12 November 2021

New Liverpool Primary School SSD – 10391

Response to Agency Submissions

PROJECT NO.	DRAWING NO.
22102	NLPS-AR-DRG-SSD-1103

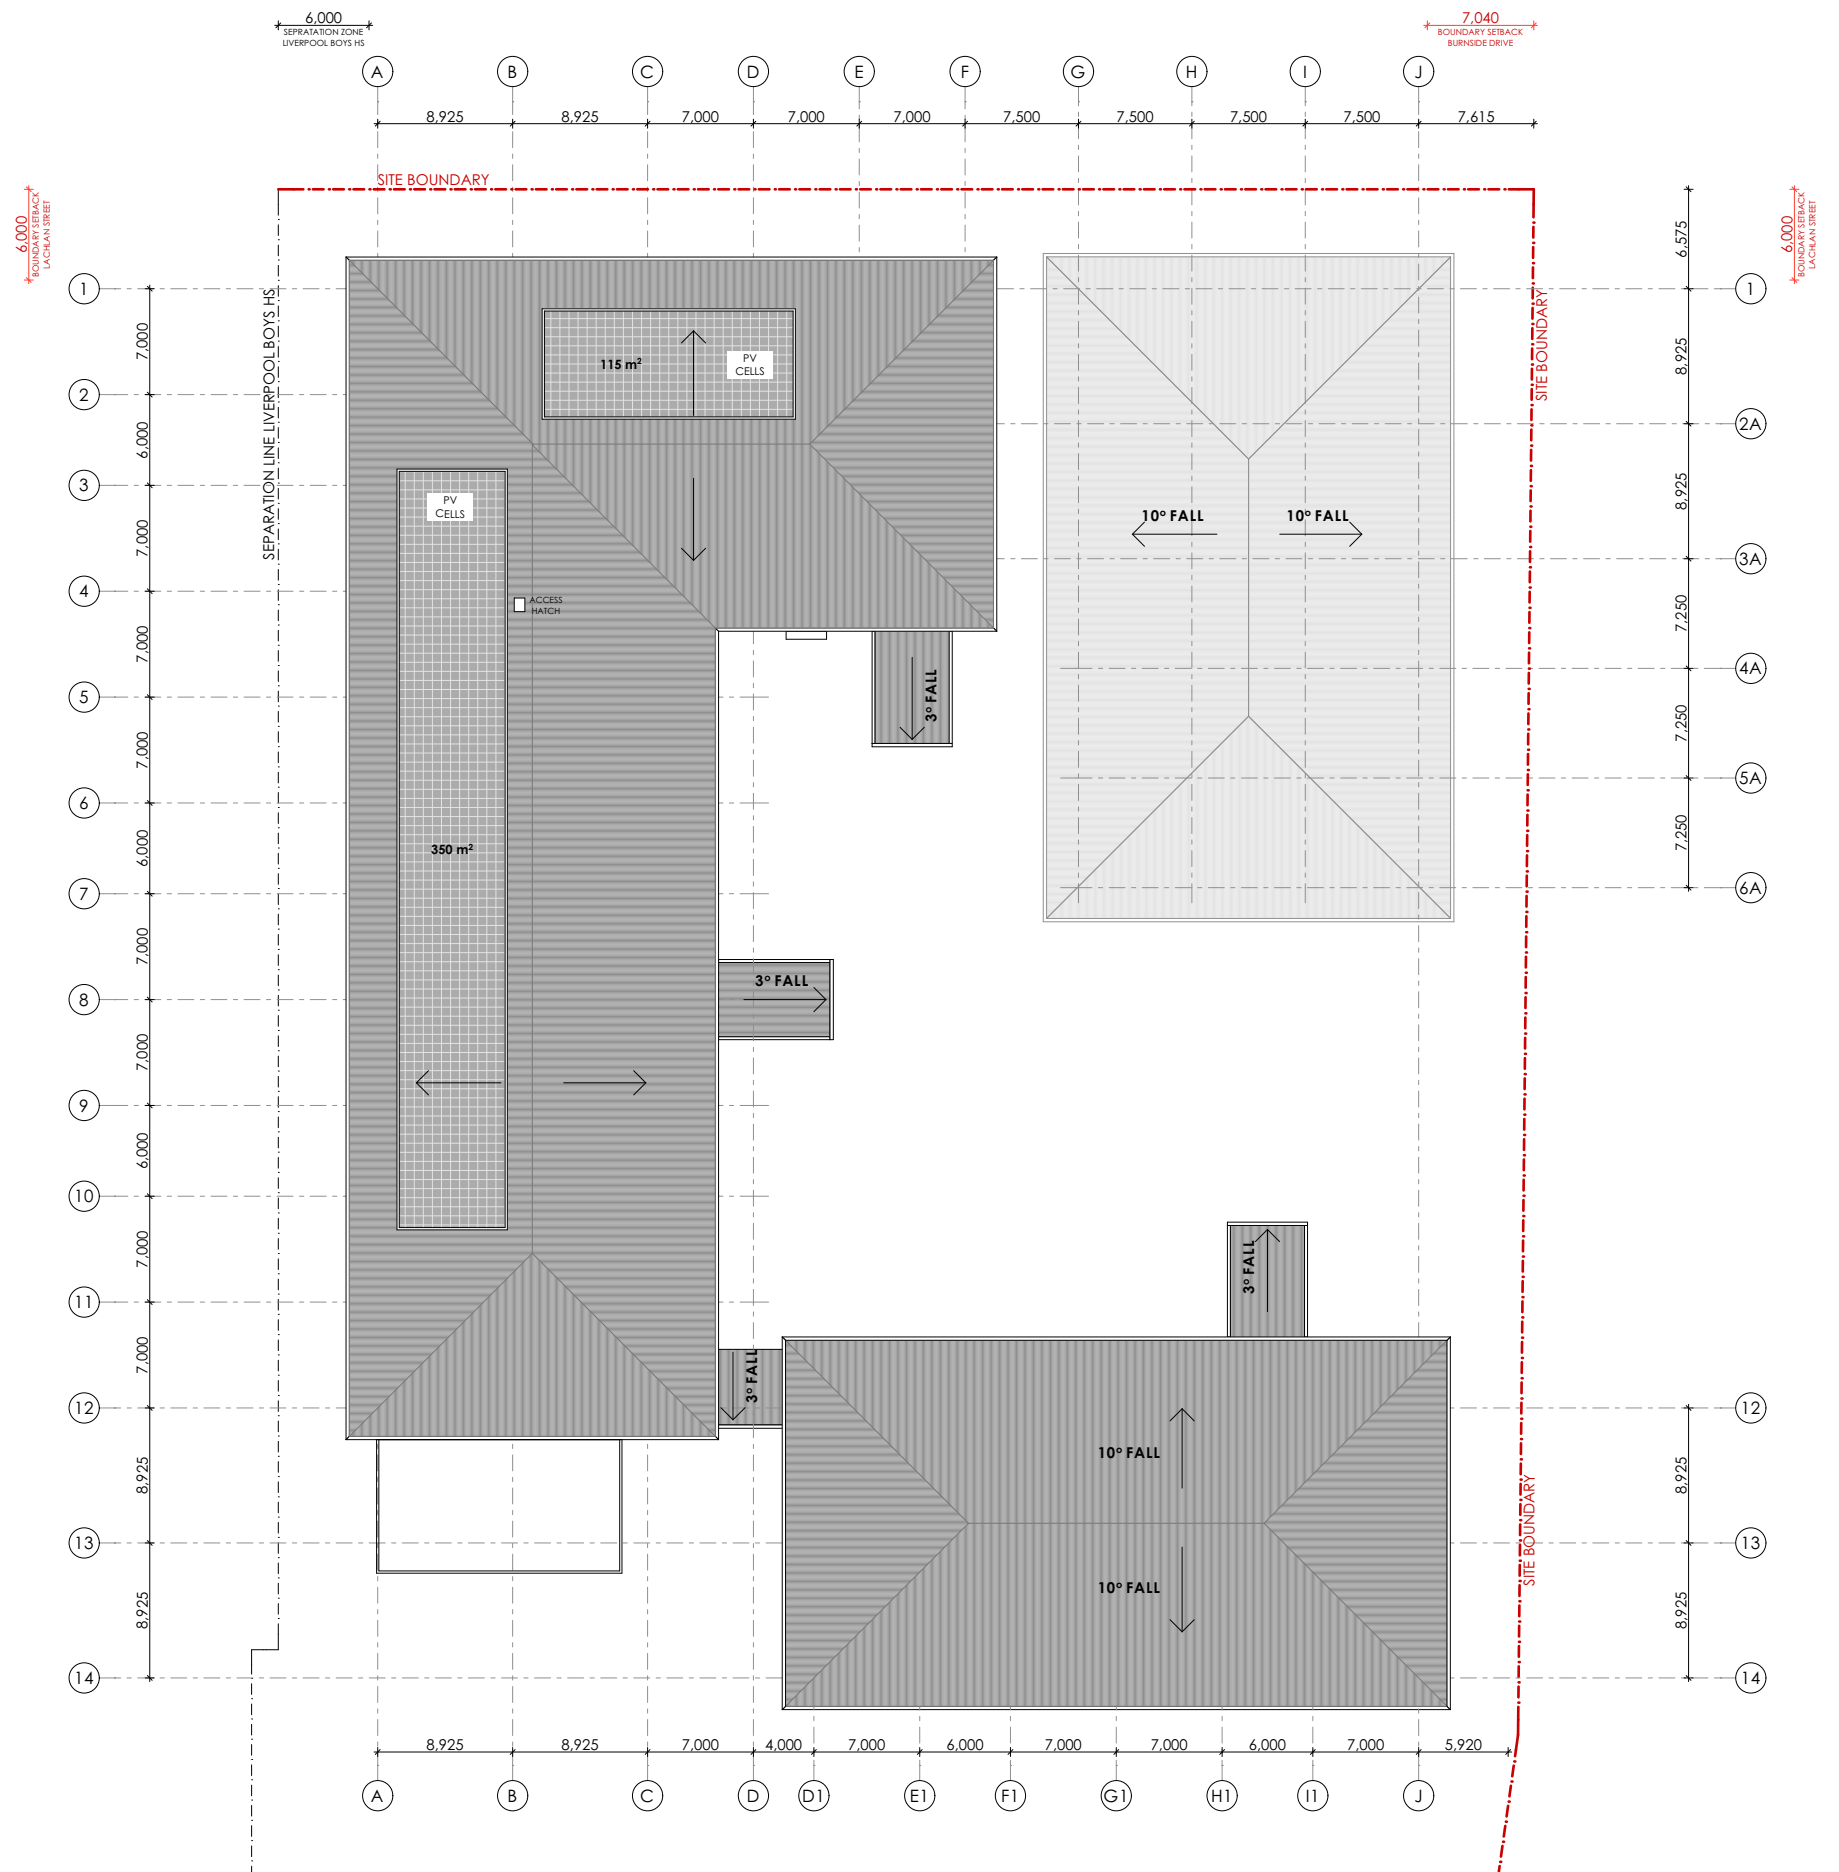
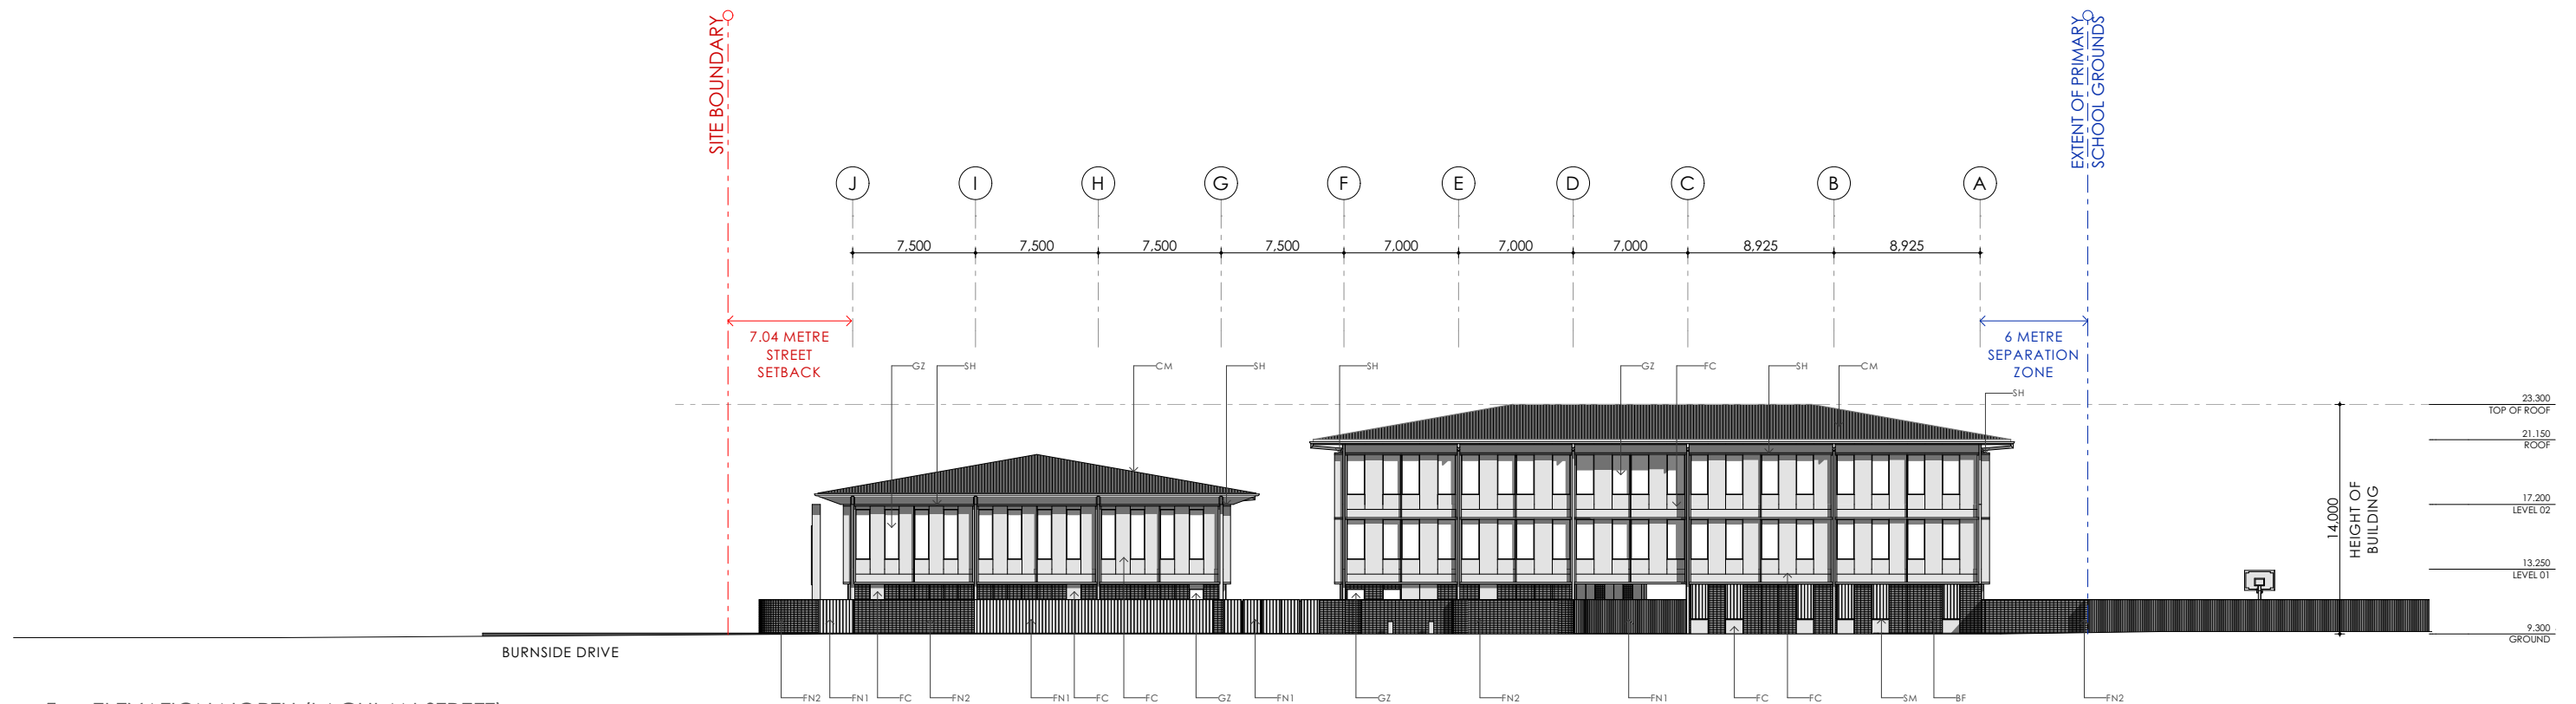
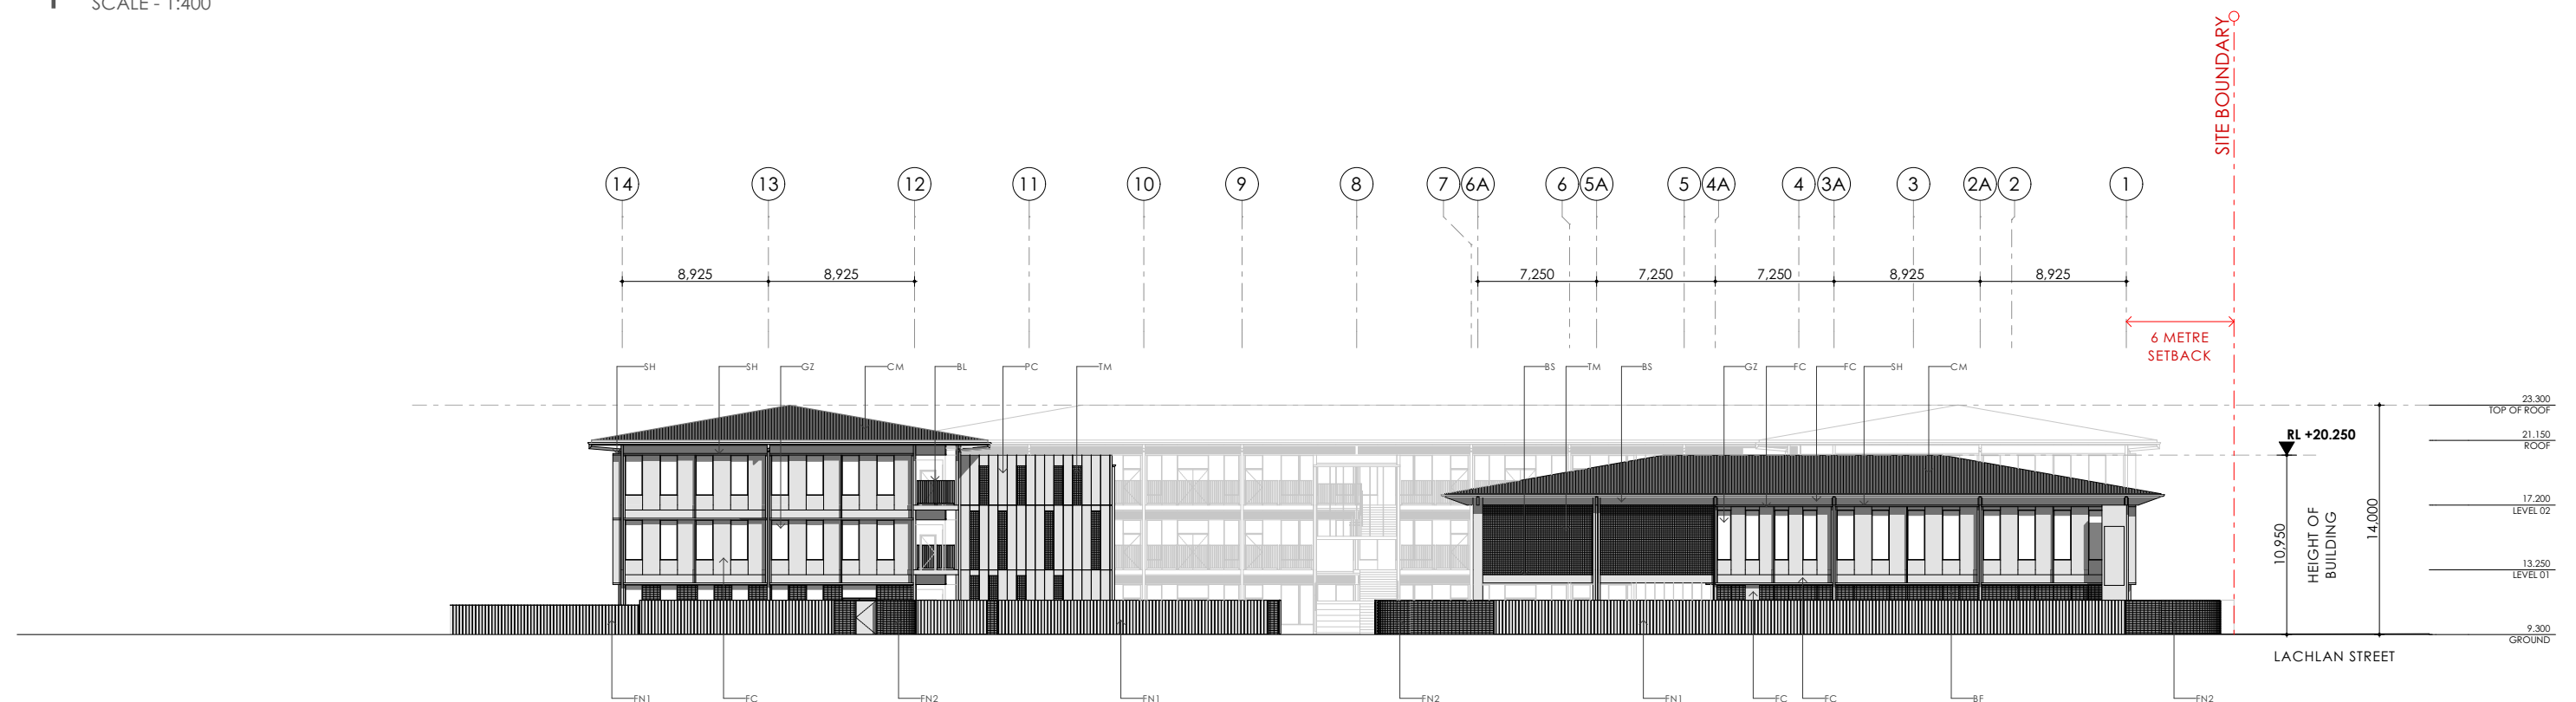
Design of the development	
Government Architect NSW (GANSW) have reviewed the EIS and have raised concerns regarding the full height glazing to the Western façade with no shading and no planting able to be facilitated along the boundary. In recognition of the western elevation, you are requested to address this issue and provide additional shading devices or articulation of this façade which can result in shading.	500mm deep vertical and horizontal sunshades have been provided to the Western façade which work with the ratio of 30% performance glazing to 70% solid façade to achieve a compliant Solar Heat Gain Coefficient of 0.6. Mid-Summer shading studies on the Western Façade show how eaves horizontal projections mitigate midday sun into West facing spaces.
Please provide details on the proposed future east/west link through the site, even if it is not finalised as yet, to demonstrate the site permeability.	The New Primary School SSDA proposal provides the opportunity for an east / west site link in the landscape to the south of the building. This aligns with the east / west site link proposed by the Liverpool Innovation Precinct Masterplan included in the SSDA Report (1-05). It is important to note the adjacent High School Site is subject to a live project proposal separate to this SSDA process, but will provide opportunity for linkages where possible and appropriate.
